**Our ref:** WA/2019/127044/01-L01  
**Your ref:** 19/01746/OUT  
**Date:** 3 October 2019

**Outline planning permission (with all matters reserved excluding access) for up to 10,200sqm of B1 development (B1a and/or B1b and/or B1c); access and associated landscaping and infrastructure works**

**Land Adj To Promised Land Farm, Wendlebury Road, Chesterton**

**7.1 Outline Planning Parameters Drawings: Land use**

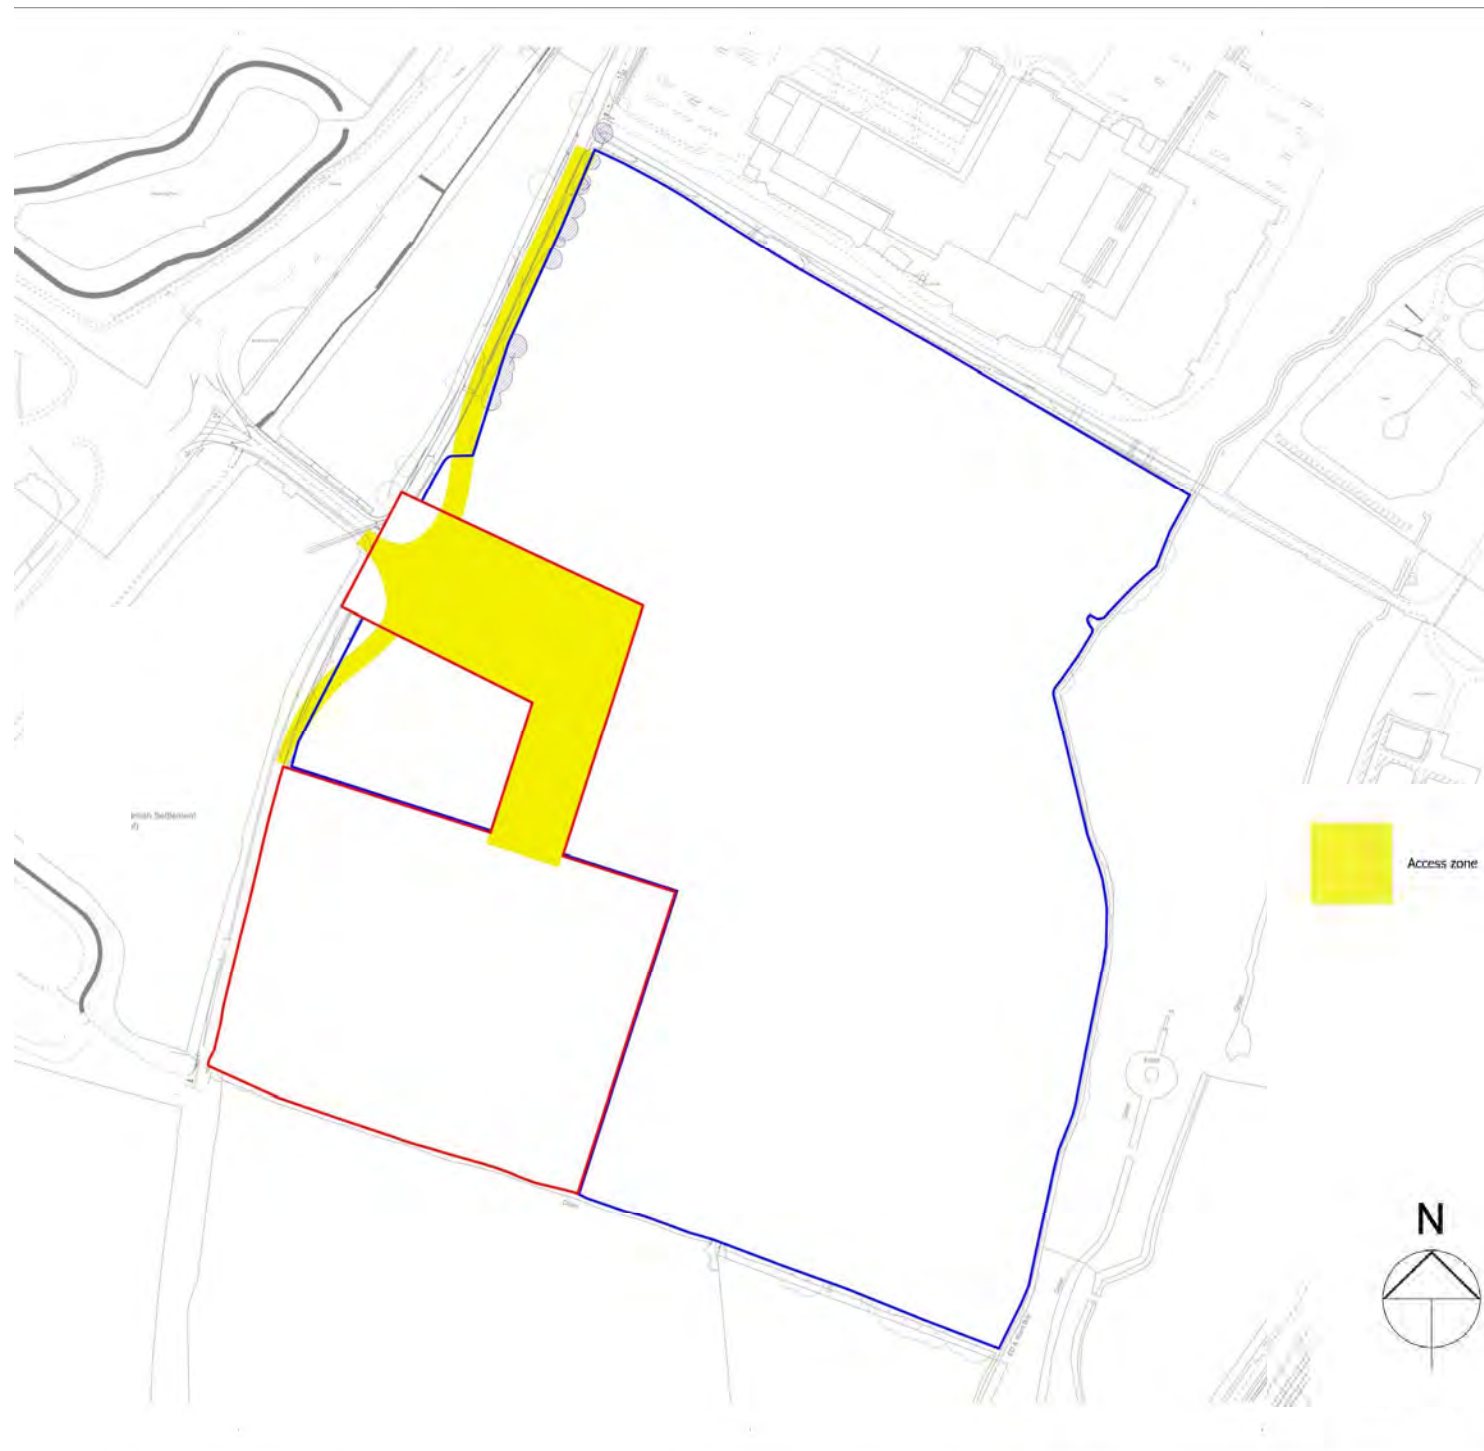
We note that this is an outline planning application, with all matters reserved except for access. An indicative site layout plan has been submitted as part of this outline submission, and this has shown encroachment into Flood Zone 3b. We note that Core Policy Bicester 10: Bicester Gateway states that there shall be no built development in Flood Zone 3b. Whilst we acknowledge that the site layout plans provided as part of this application are indicative, we need confirmation within the Flood Risk Assessment that there will be no built development within the existing Flood Zone 3b extent.

We **object** to the proposed development as it falls within a flood risk vulnerability category that is inappropriate to the Flood Zone in which the application site is located. The application is therefore contrary to the National Planning Policy Framework and its associated planning practice guidance. We recommend that planning permission is refused on this basis.

The PPG classifies development types according to their vulnerability to flood risk and provides guidance on which developments are appropriate within each Flood Zone. This site lies within Flood Zone 3b functional floodplain, which is land defined by your Strategic Flood Risk Assessment as having a high probability of flooding.

The development is classed as less vulnerable in accordance with Table 2 of the Flood Zones and flood risk tables of the PPG. Tables 1 and 3 make it clear that this type of development is not compatible with this Flood Zone and therefore should not be permitted.

We will be in a position to remove our objection to this development when the applicant submits an indicative layout showing all built development outside of Flood Zone 3b.

Figure 7: Preliminary Flood Compensation Scheme 1 (Drawing No. S1358-Ext-35A)

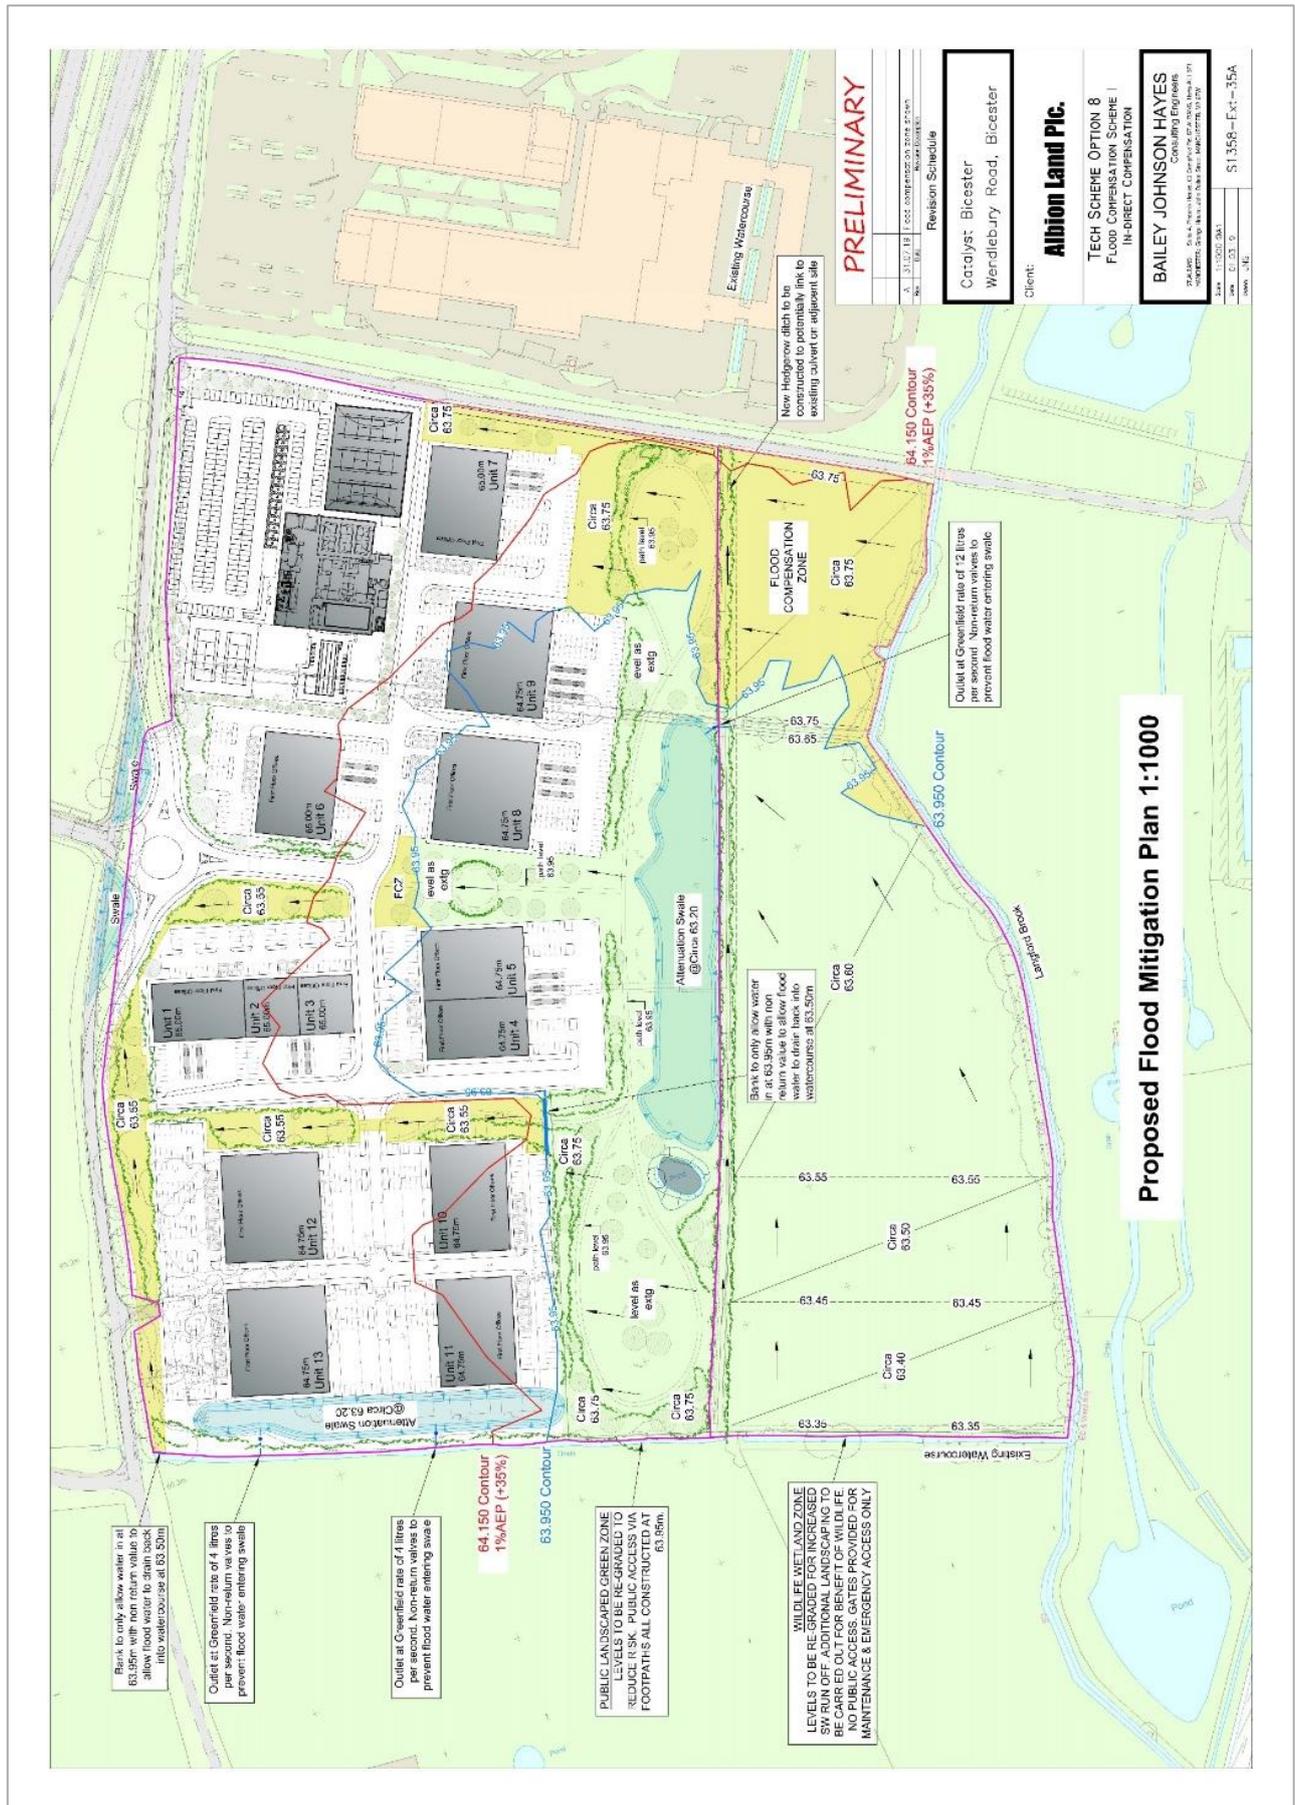
There is no detail in the FRA in respect of how much compensation is necessary for the loss of floodplain storage and how this can be incorporated into the site. We expect flood compensation to be provided on a level for level basis up to the 1 in 100 plus 35% flood level. This detail is something we are unable to condition as we need to know that level for level compensation is achievable before outline permission is granted.

To overcome our objection, the applicant should submit a revised FRA which addresses the points highlighted above. If this cannot be achieved, we are likely to maintain our objection. Please consult us on any revised FRA submitted and we will respond within 21 days of receiving it.
